From: Piers Carlisle | Haines Phillips Architects [REDACTED]
Sent: 03 June 2020 10:28
To: Zac Denton <[REDACTED]>
Cc: Martyn White [REDACTED]
Subject: Re: AB/32/20/DOC - Clarification

Please find attached drawings for yours and Mr White's attention in answer to his queries relating to the above Application to Discharge Conditions. I shall address these below:

This application is regarding your Discharge of Conditions application at Old Wheatsheaf House, 31 Maltravers Street.

Basement Staircase Plans

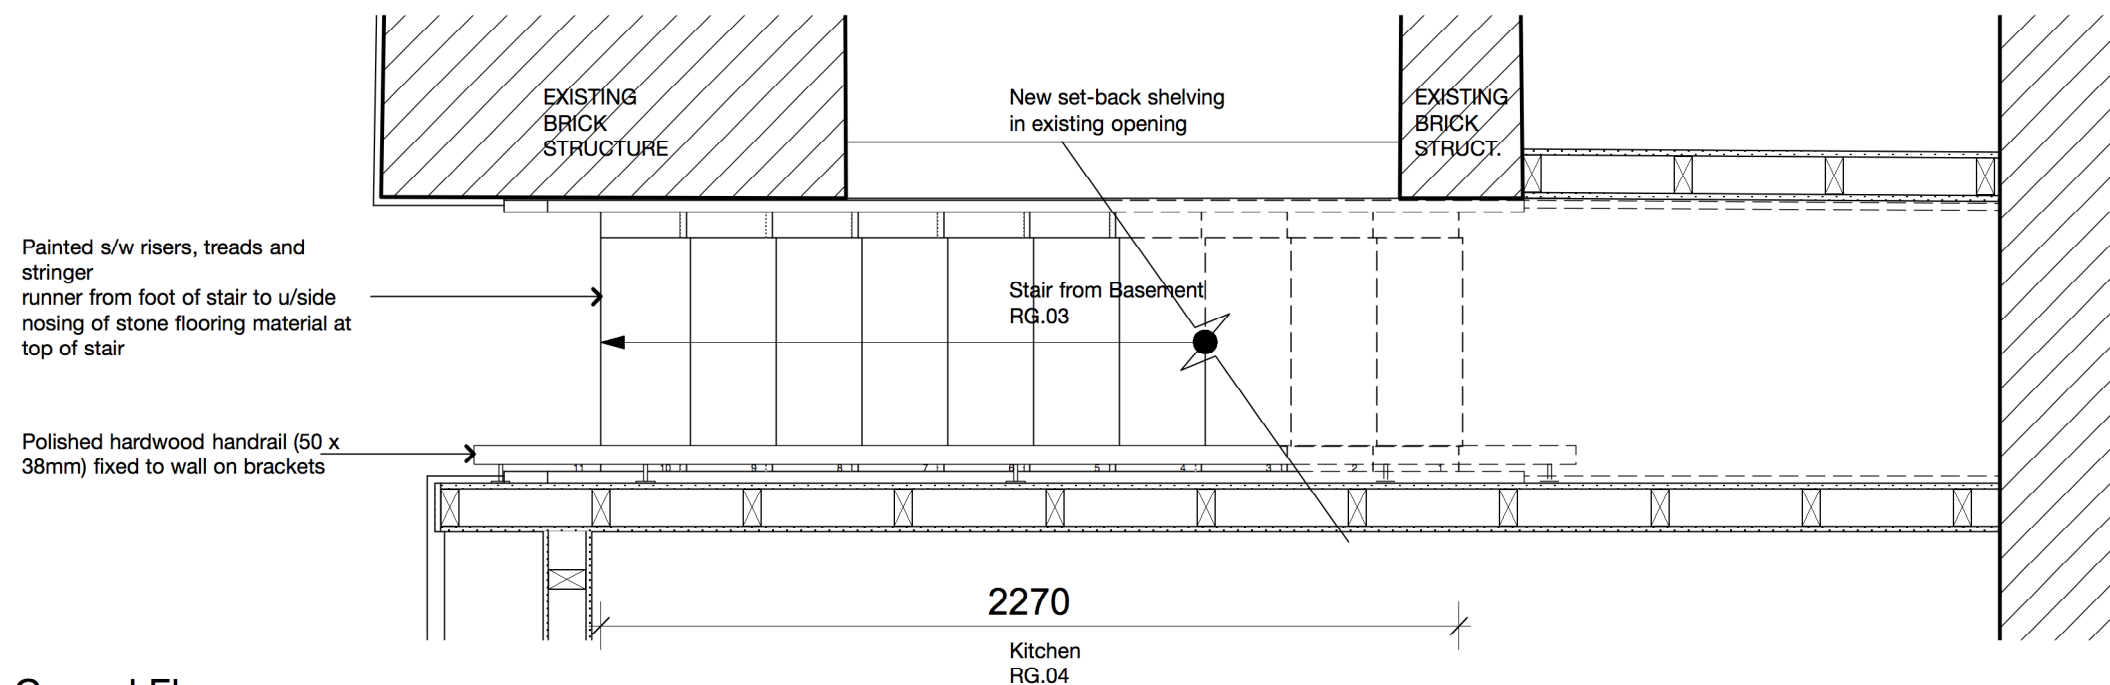
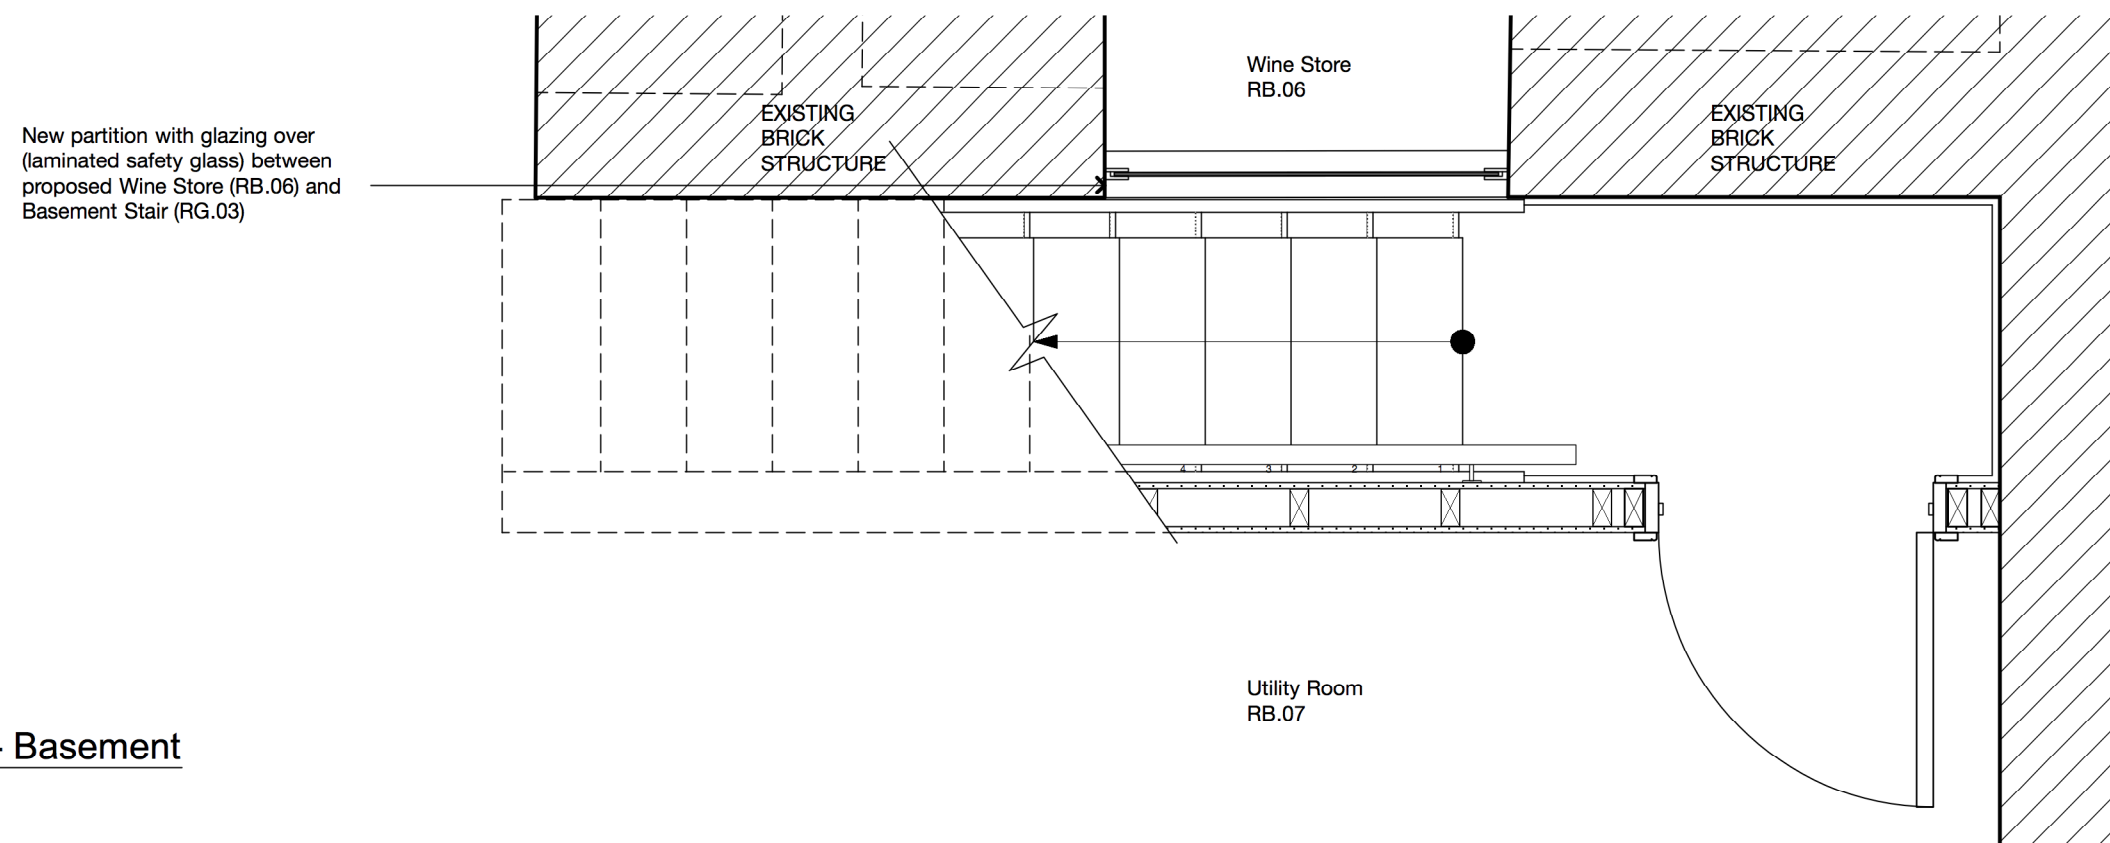
Enclosure of stair between ground floor and basement level at basement level – noted.

**Proposed Garden Gate  
Garden Elevation**

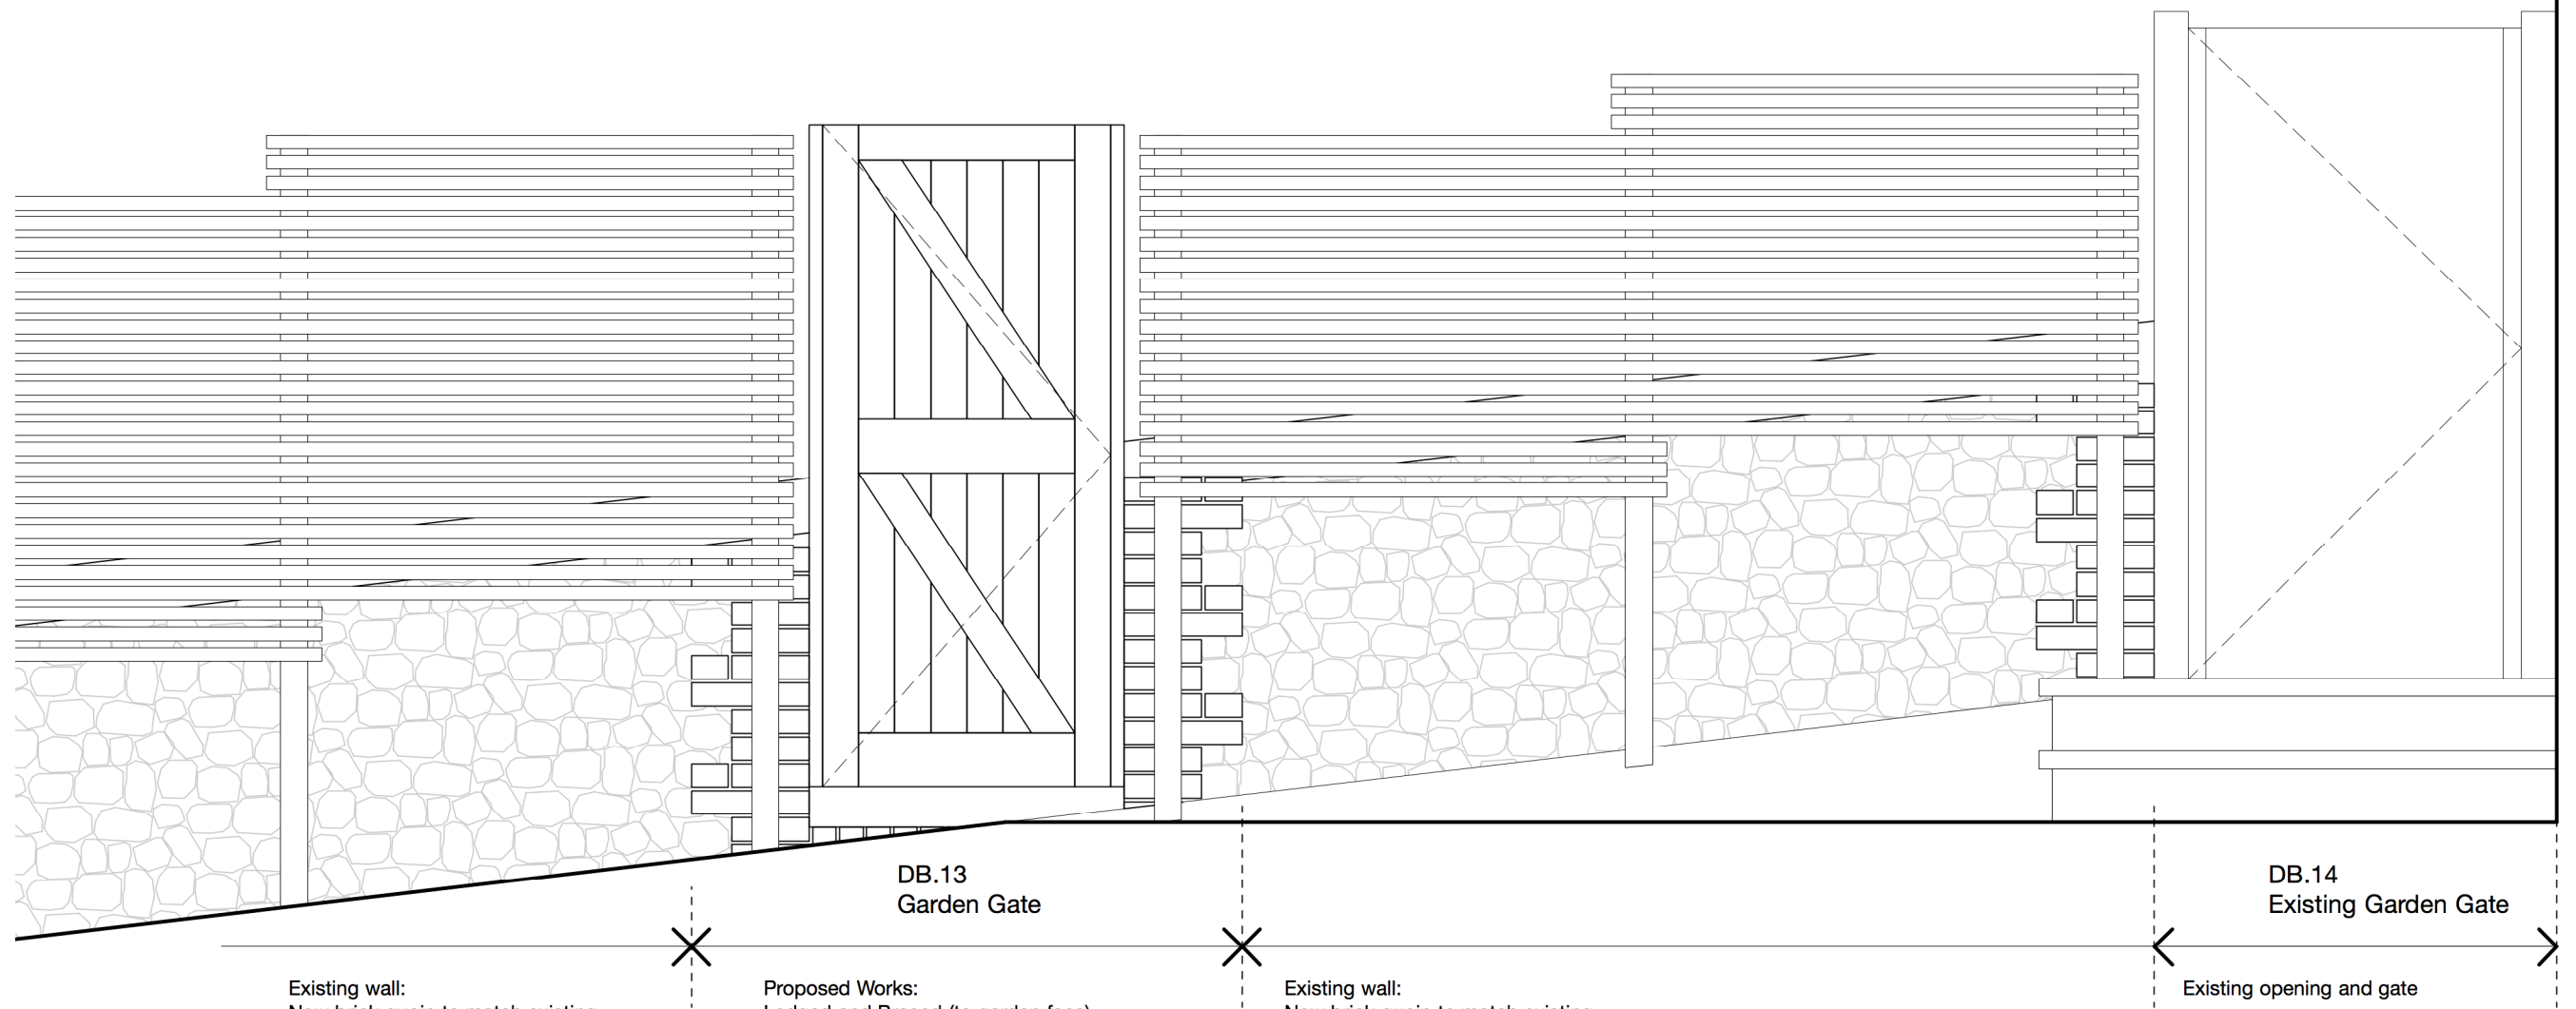
Fencing included on garden plans – this was not included in original consent but, upon further inspection the fence was in a very poor state. For this reason it is proposed to replace the existing fencing (close-board timber) with a style of fence that matches the trellis over the stair from garden to Ground Floor terrace on the other side of the property. We felt that this would be sympathetic to the scheme as a whole.

11.2019			
									1:20@A3			
									JOB NR			
									DRAWING NO.			
									ISSUE			
									REVSON			
									4120			
									DA 401			
									PL			
									3

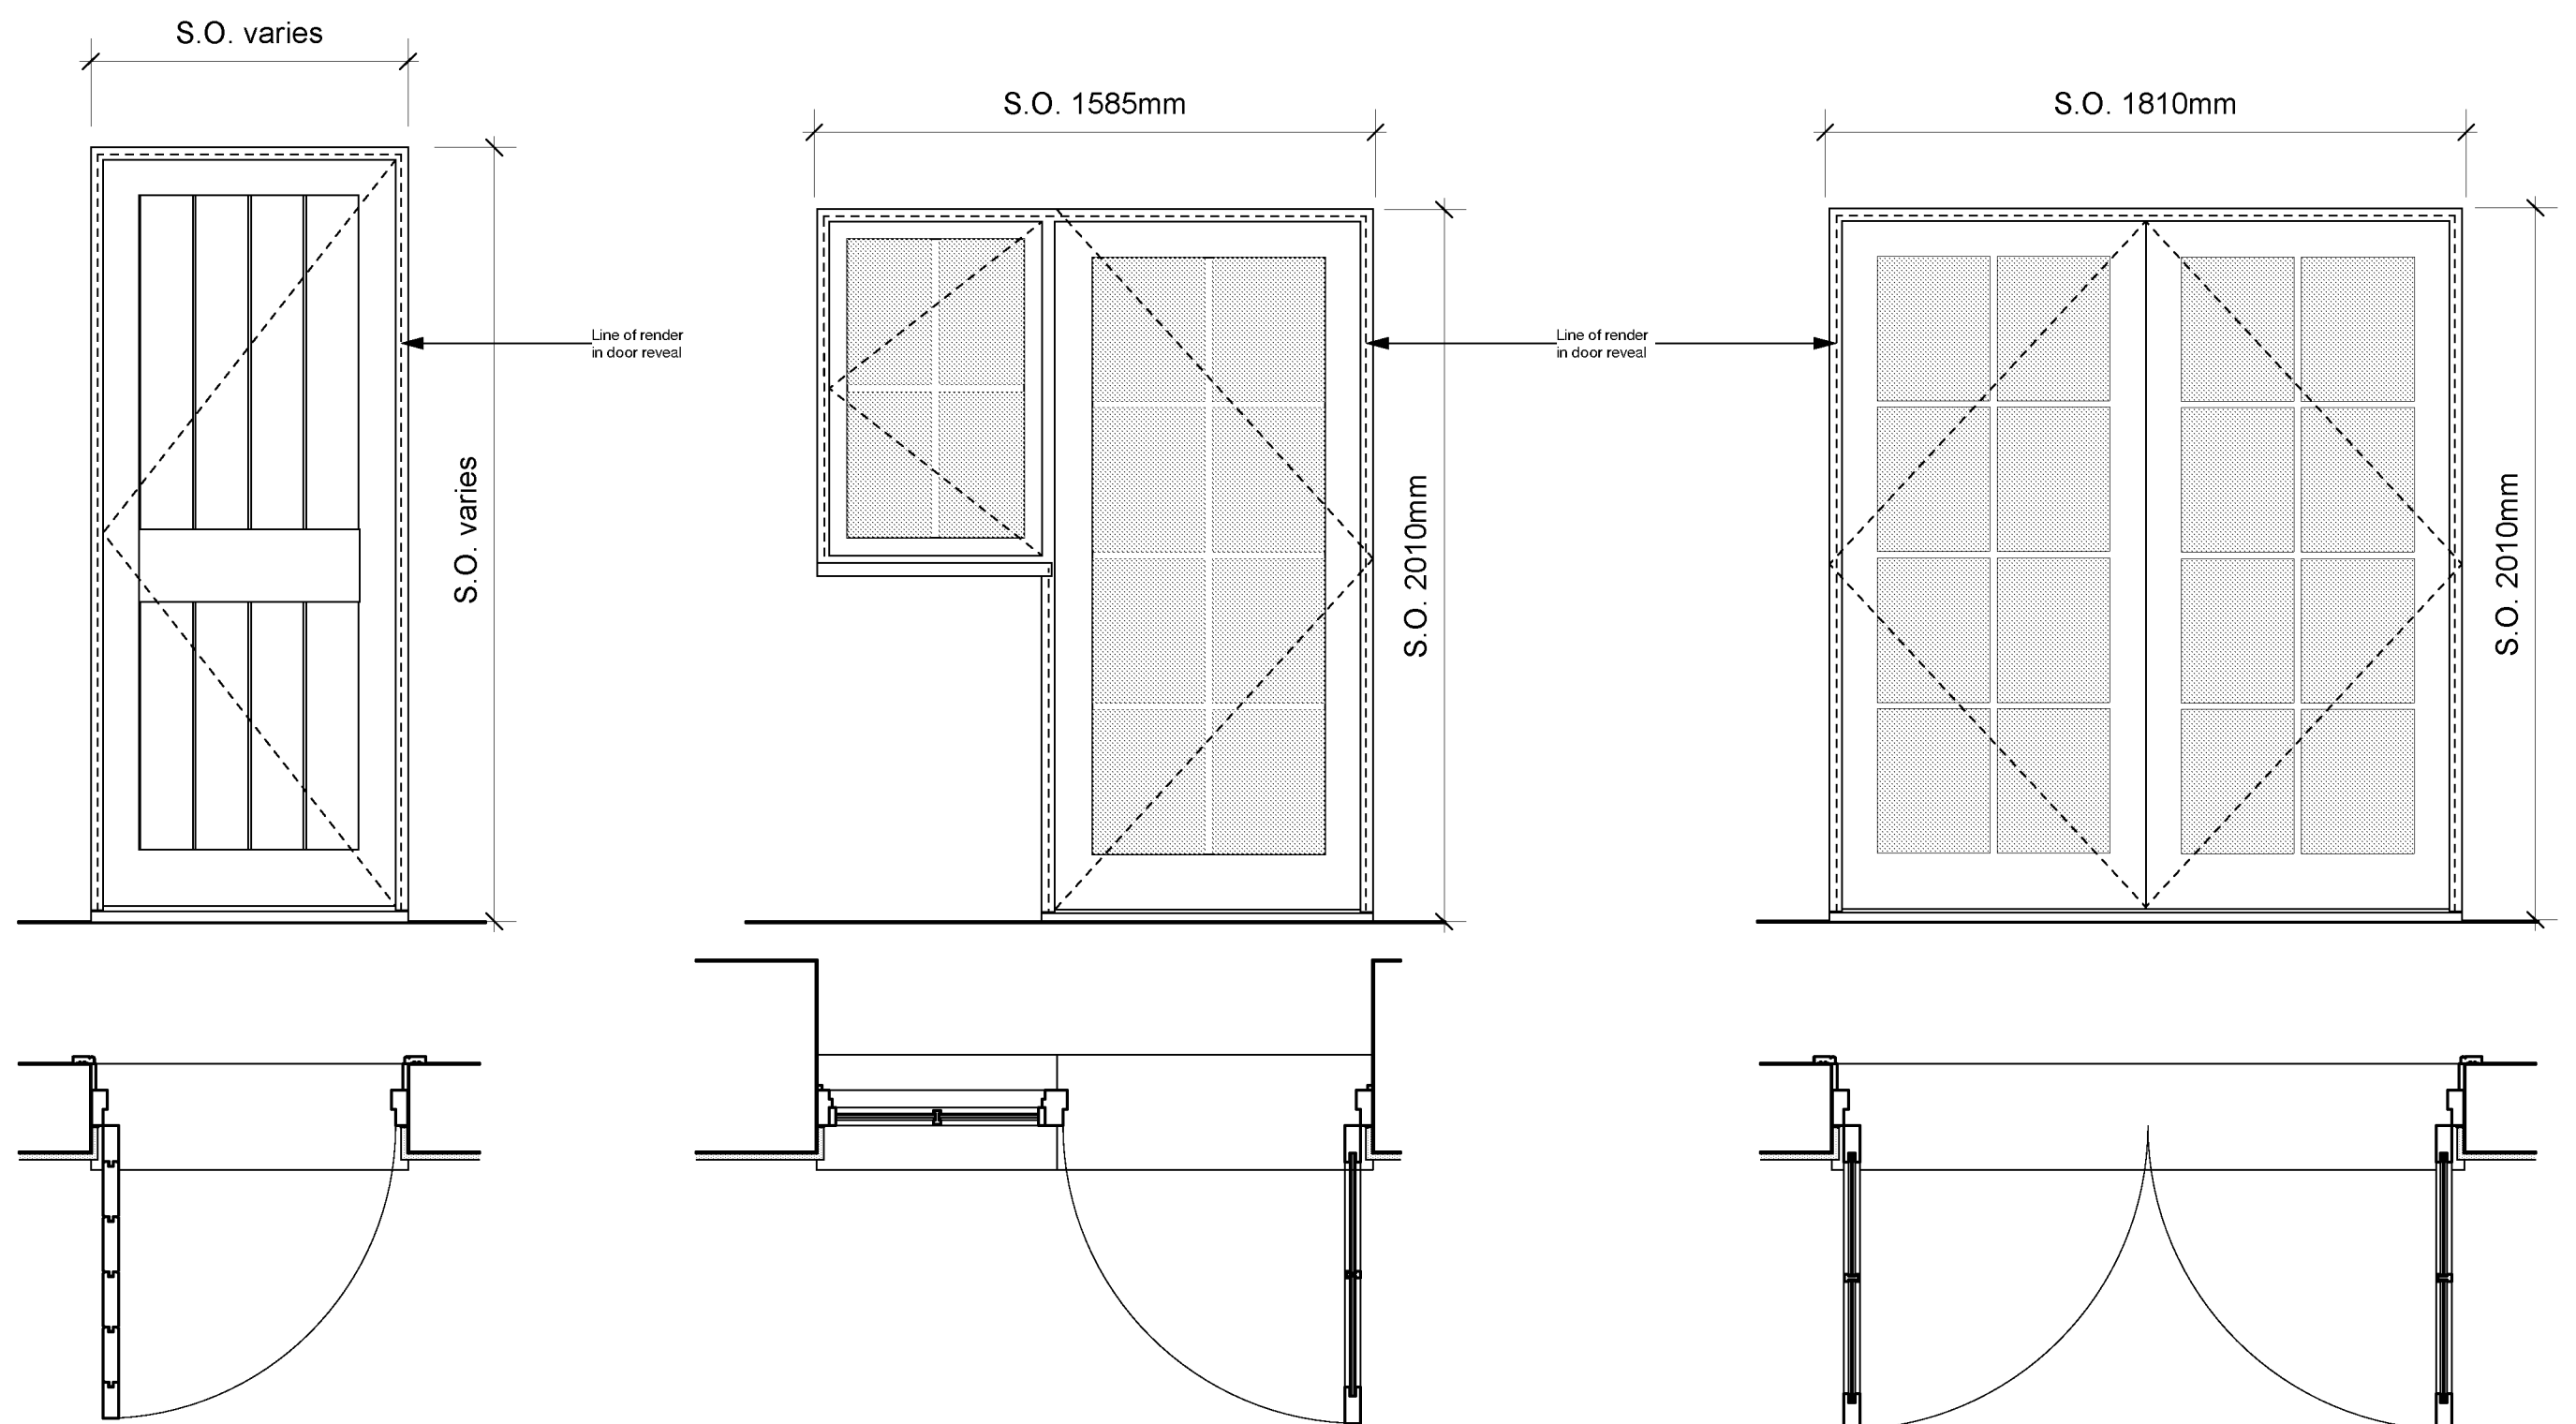
Door type B – there were some changes to the layout in the Annex but this has now reverted to the original layout. However, a French door with a side-panel is to be fitted in this location, rather than the double French doors originally shown in the Planning and Listed Building applications. This was to reduce the increase to the width of the opening. The side-panel is now side-hung. The entrance door to the Annex is a Type A door – as originally intended in the original Planning and Listed Building applications.

Glazing bars to doors will be integral (slimline double-glazing).
